**From:** Contact Centre (CRM) <contact@ribblevalley.gov.uk>  
**Sent:** 05 May 2026 16:46  
**To:** Planning  
**Subject:** Planning Application Comments - 3/2026/0258 FS-Case-834941231

**Planning Application Reference No.:** 3/2026/0258

**Address of Development:** Land adjacent to Abbeycroft Whalley

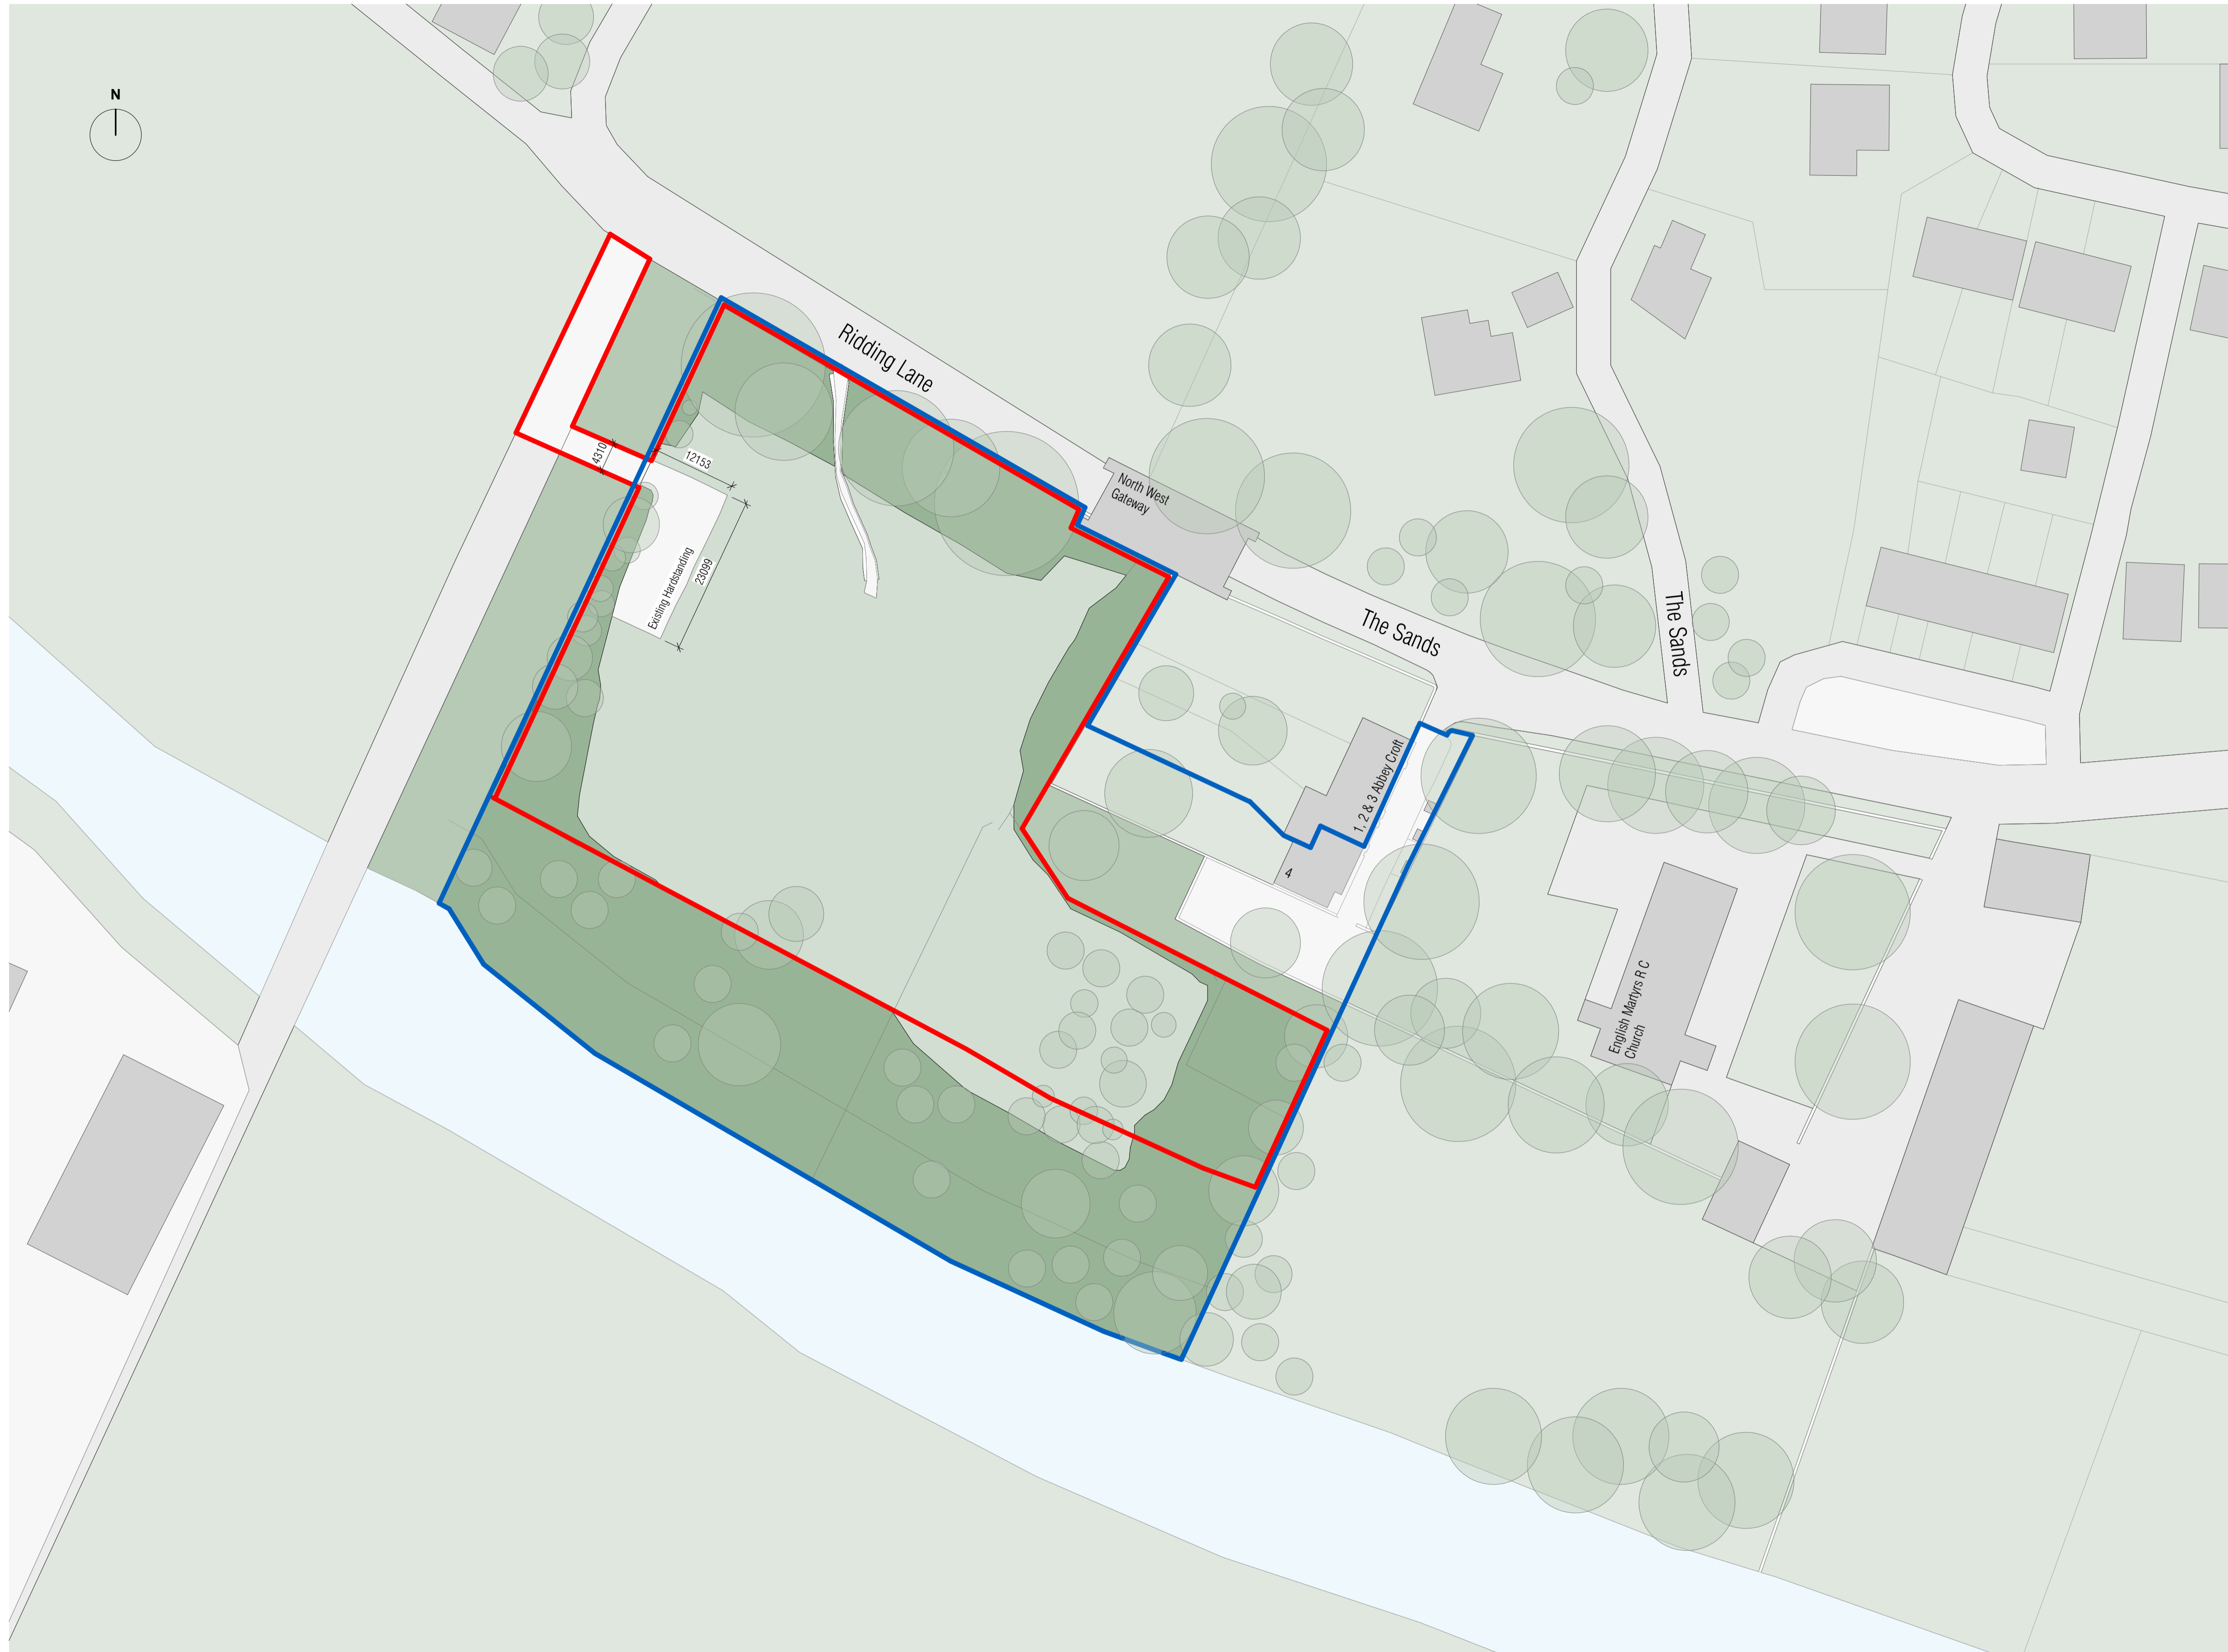
**Comments:** The submitted documents state that the proposed access is from Ridding Lane. This is incorrect. The plans indicate that access will be from the Footpath between the Broad Lane/Ridding Lane junction and Longworth Road. This is shown on the OS map as a footpath - not a vehicular road. The site already has direct access from Ridding Lane through the old field gate adjacent to the North East Gatehouse.
